RE: 7-Eleven
1360 NC 24-87
Cameron, NC 28326

This letter acknowledges review of plans for the remodel of the above referenced establishment. The original plans dated 06/06/25, revised application, and specifications, including email correspondence are conditionally approved with the following comments:

2 DOMESTIC WATER PIPING PLAN - NEW WORK
Scale: 1/4"=1'

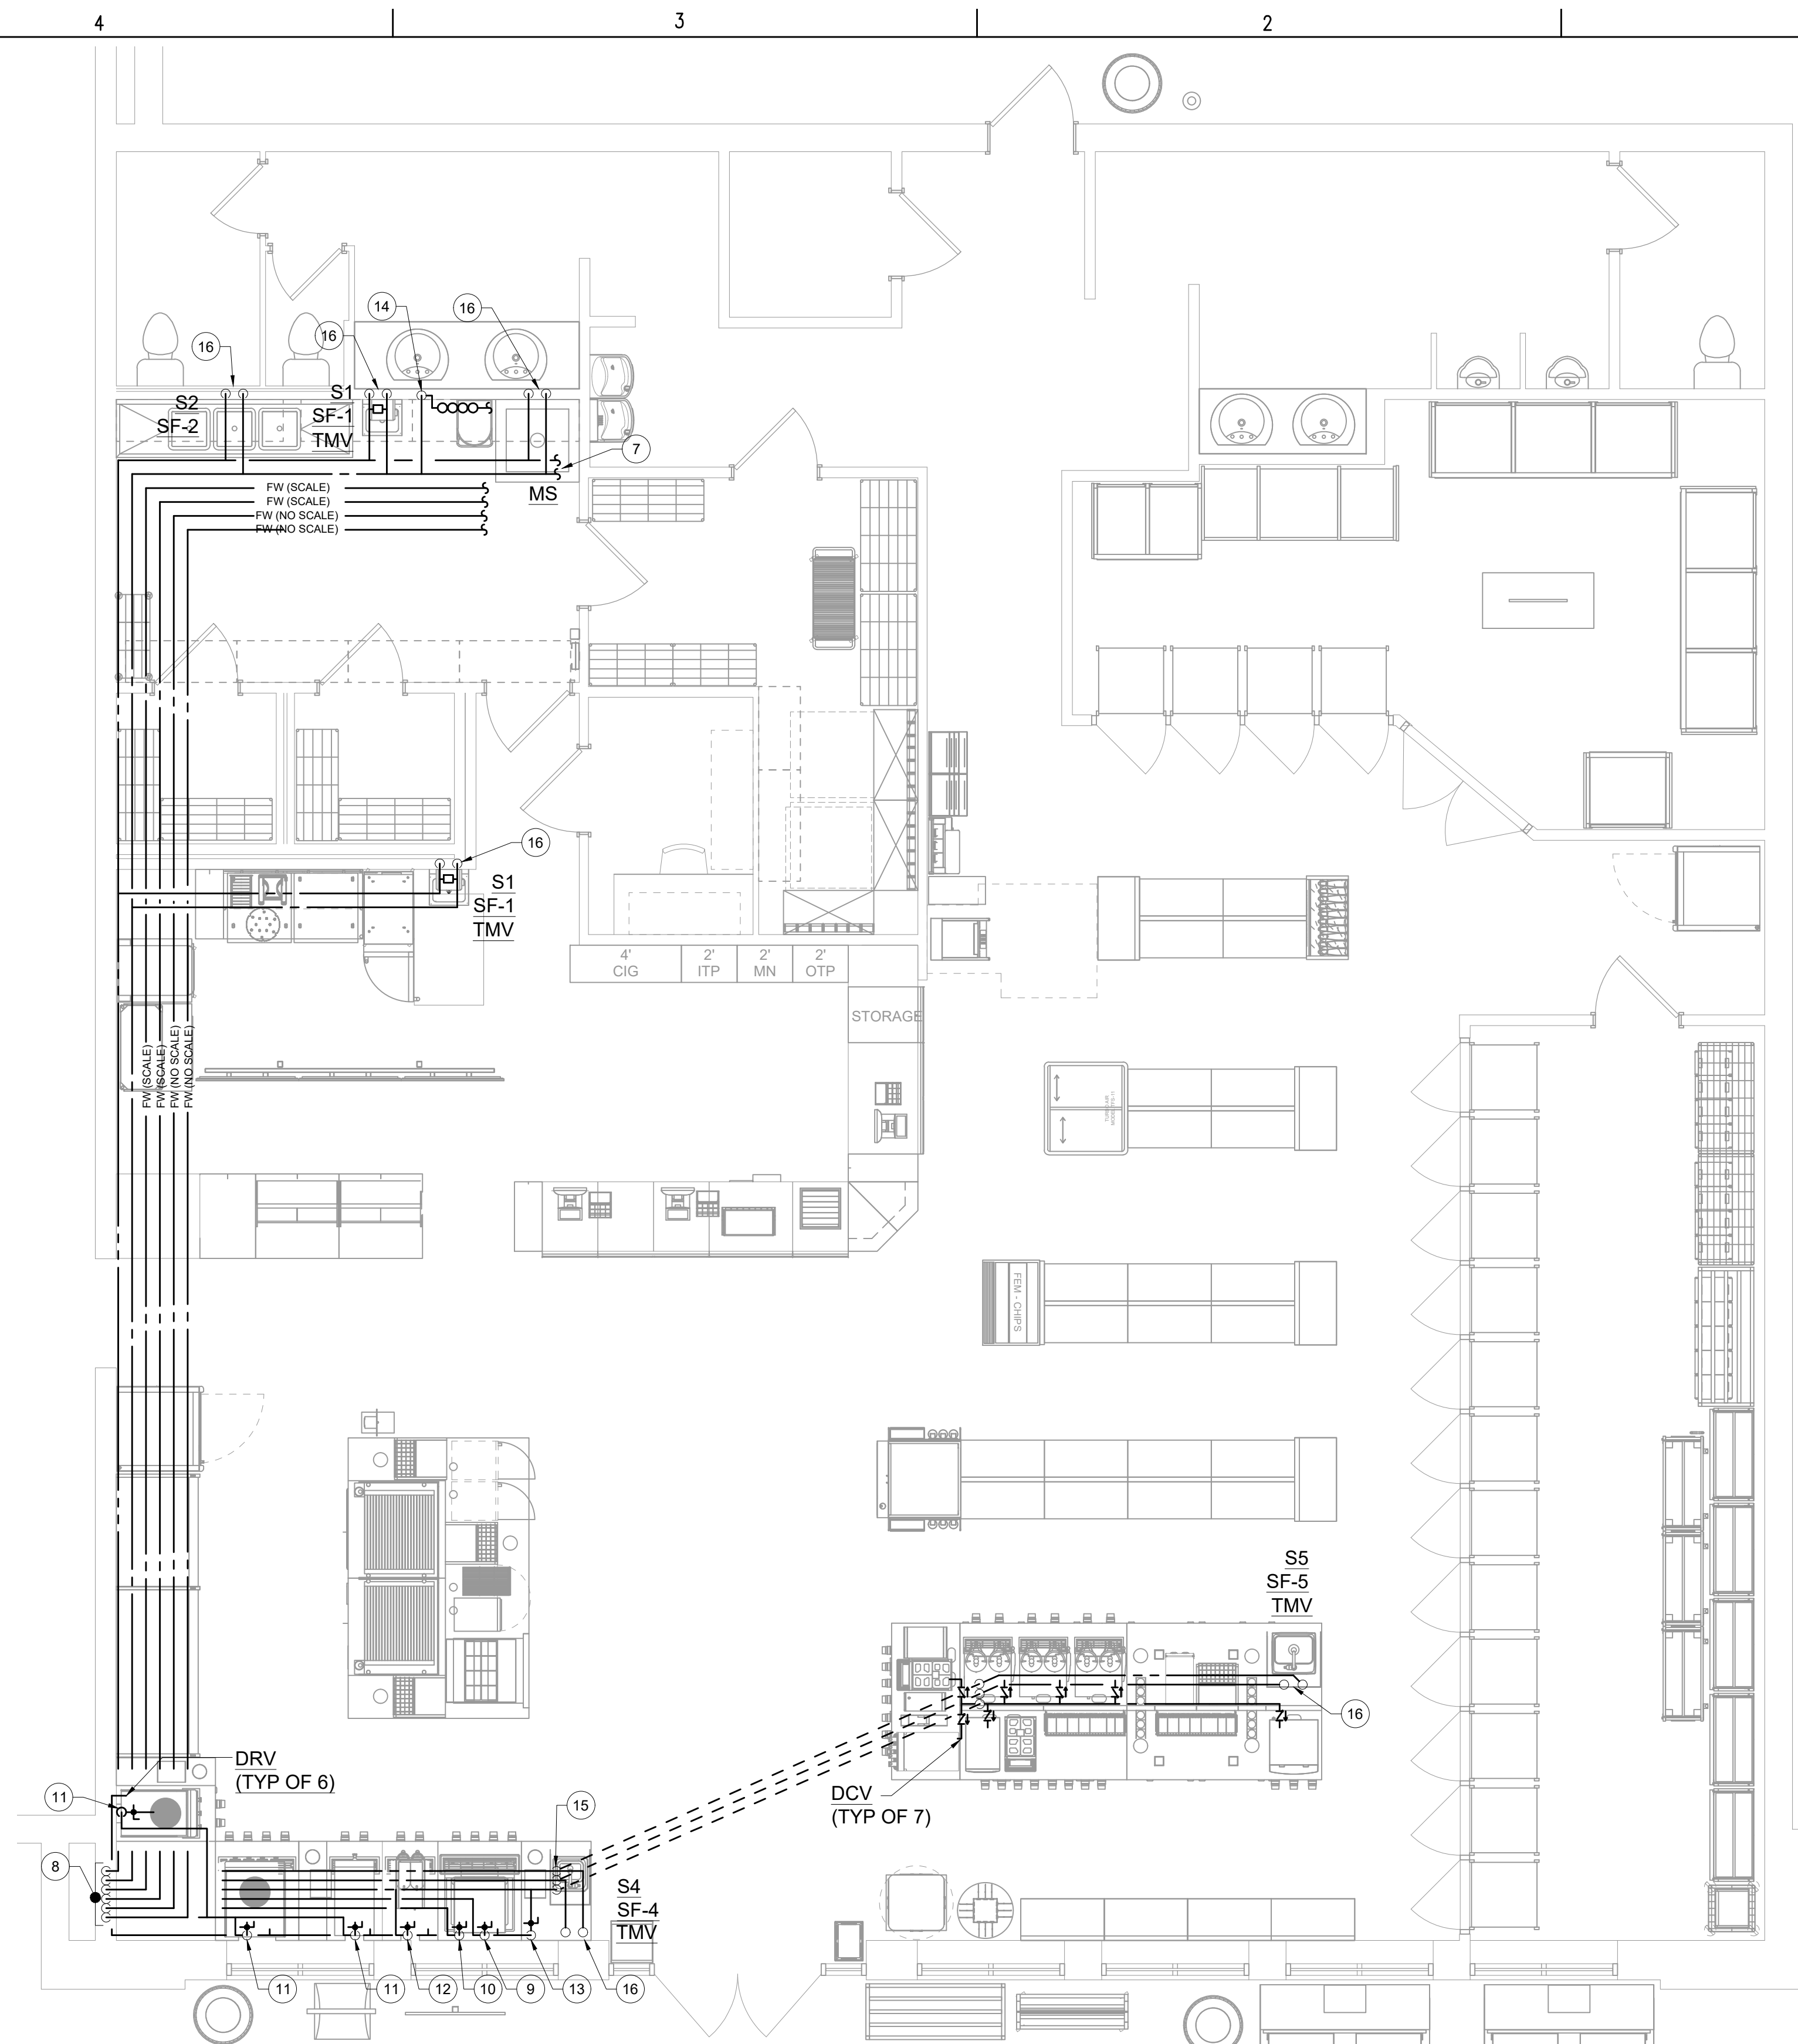
4. Plumbing must comply with all applicable plumbing regulations. These shall comply with Parts 5-1 and 5-2 and Parts 6-3, 6-4, and 6-5 of the Food Code. The Drain Piping Plan on sheet P1.0; Domestic Water Piping Plan on sheet P1.1, and P2.0; Plumbing Details and Schedules plan sheet are conditionally approved with the (2) 199MBH tankless water heaters as noted on sheet P2.0, and on the revised application. It is understood with the acceptance of engineered sealed drawings, if the design of
